From: Finlay Gardner <Finlay.Gardner@arun.gov.uk>
Sent: 27 November 2020 10:16
To: Planning.Responses <Planning.Responses@arun.gov.uk>
Subject: FW: FP/196/20/HH

From: Richard Wickens
Sent: 23 November 2020 08:54
To: finlay.gardner@arun.gov.uk <finlay.gardner@arun.gov.uk>
Cc: Glen Hewlett <[REDACTED]> David Smart <[REDACTED]> Paul English <[REDACTED]>
>; Heather Alderton <[REDACTED]>
Subject: FW: FP/196/20/HH

block plan

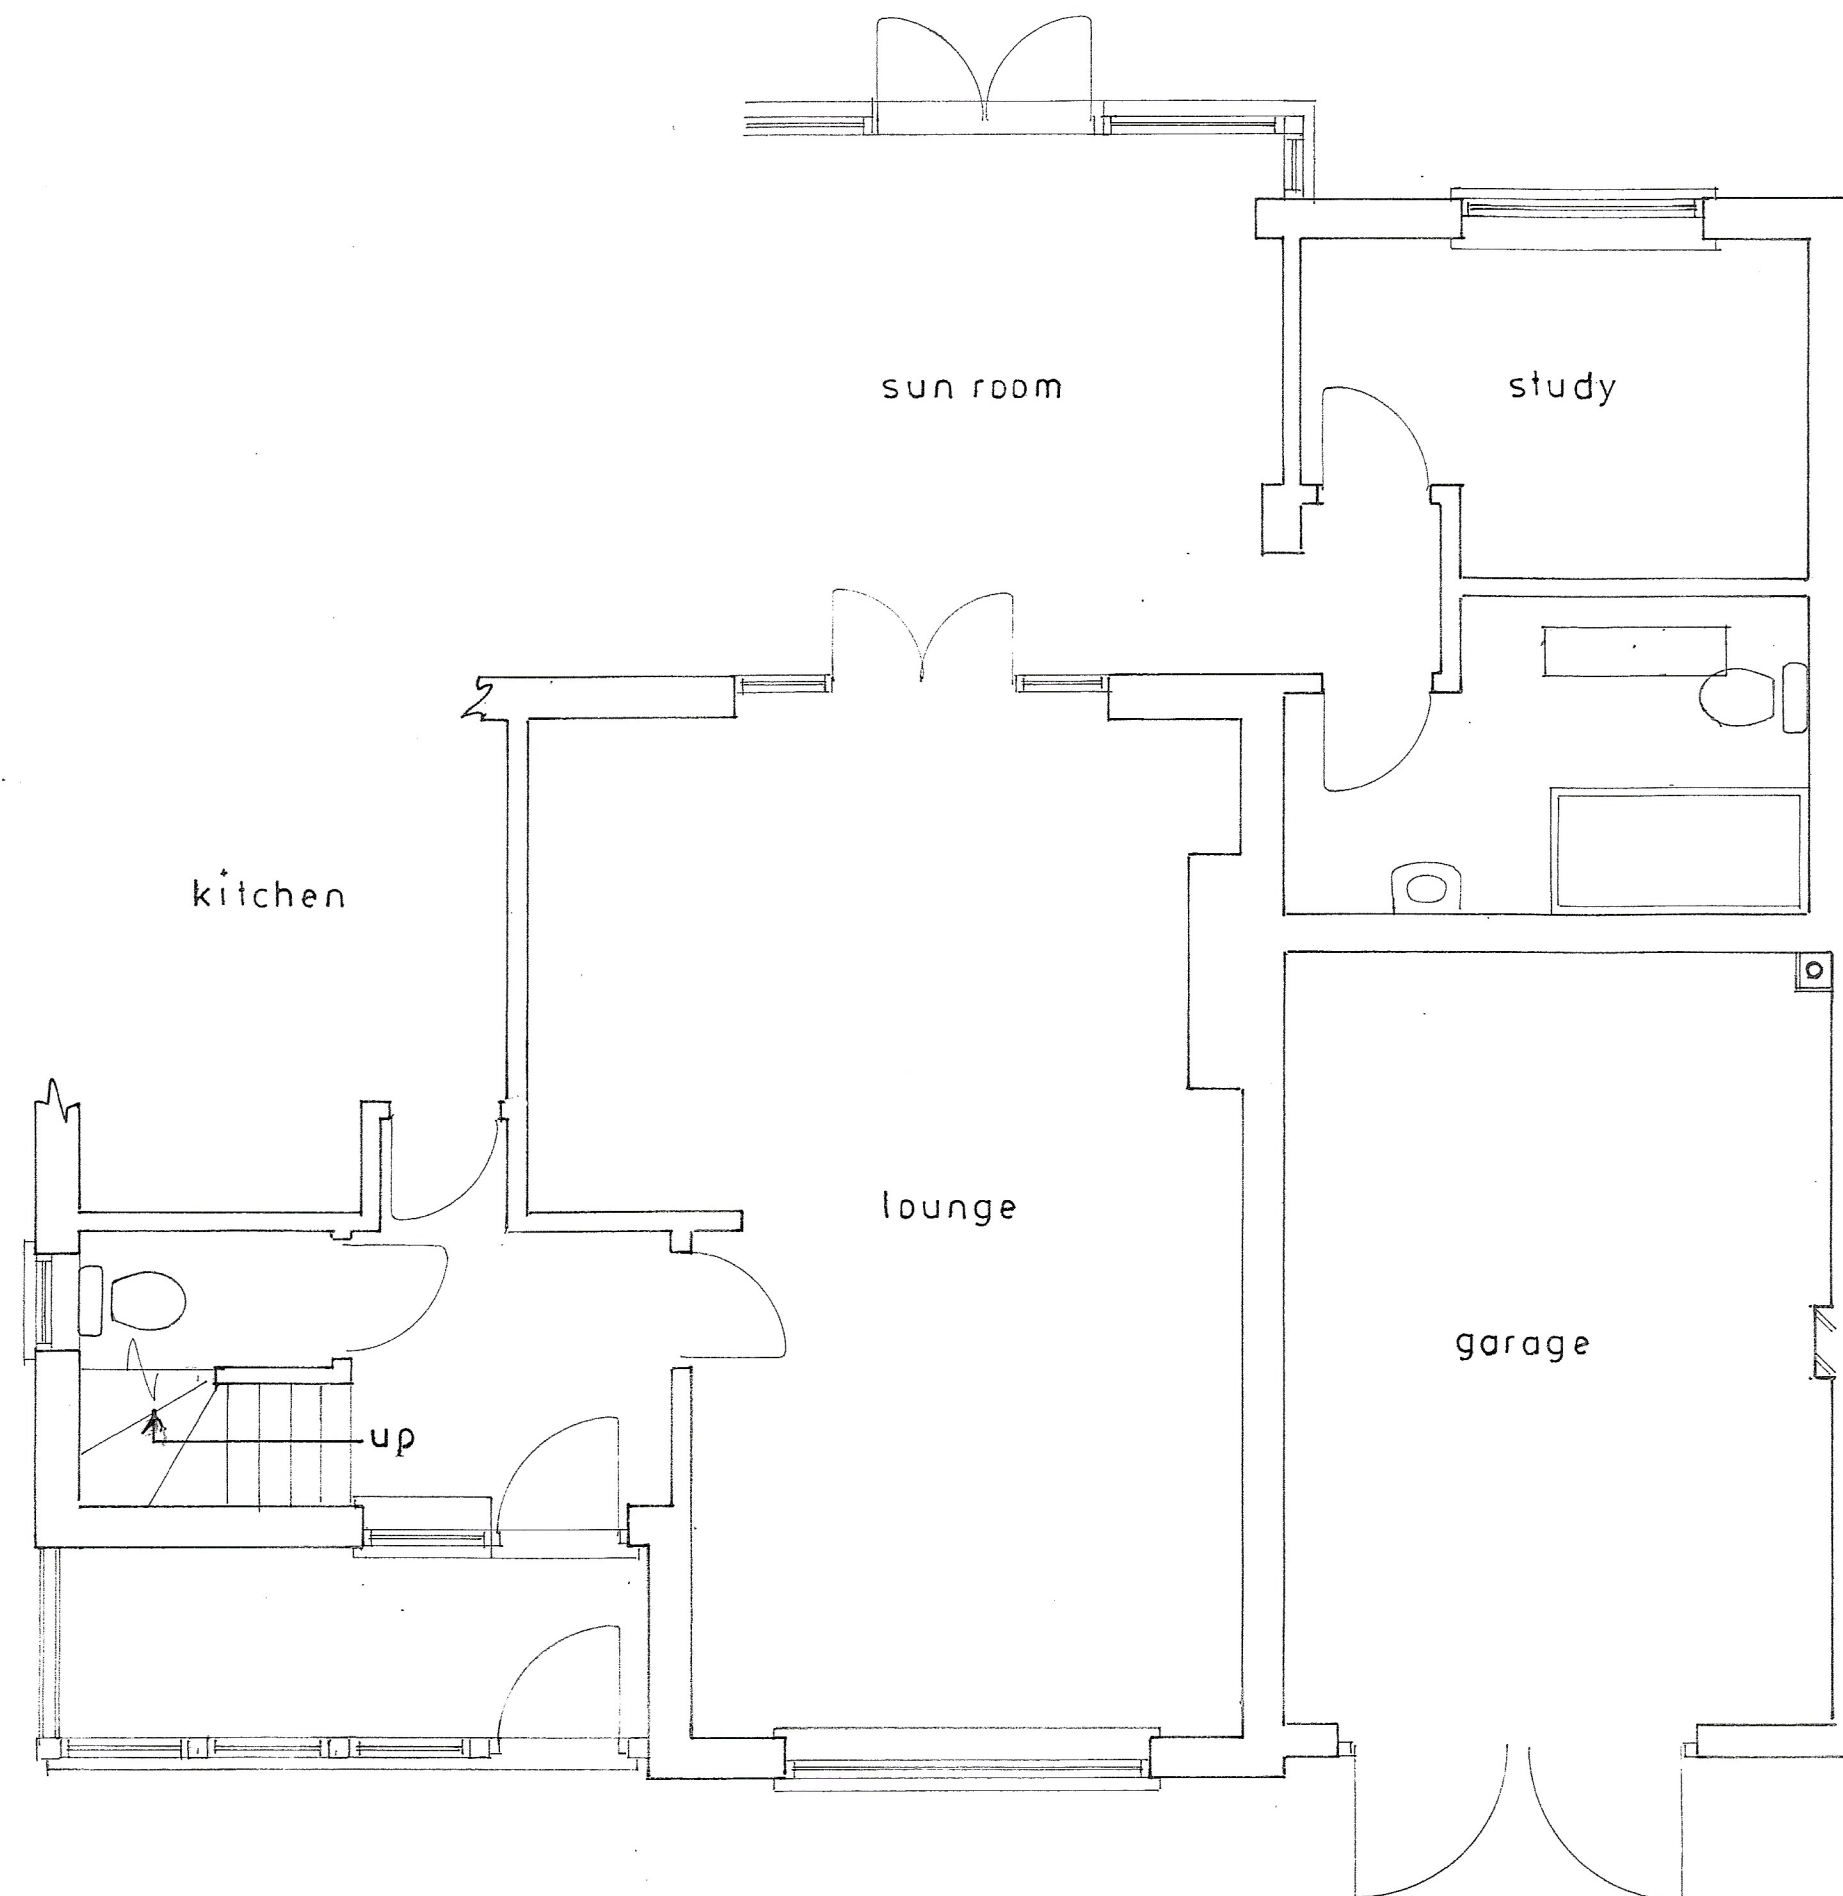
It appears that the proposed first-floor extension, on the block drawing, goes right to the boundary fence and thus does not conform with **ADC local plan policy DM4**. This requirement is detailed on **page 12 item (d)** of the attached portion of the Local Plan. The proposed elevations drawings, that were received by us, did not indicate the closeness of the boundary and thus was a poor piece of work by the architect. It is only apparent by the **omission of a dimension** that the work appears to be right up hard against the property boundary. If I or any other members of our Planning committee had picked up on this at the time it almost certainly would have led to the Parish Council objecting to the application on this ground. Hence our change of mind on this now.
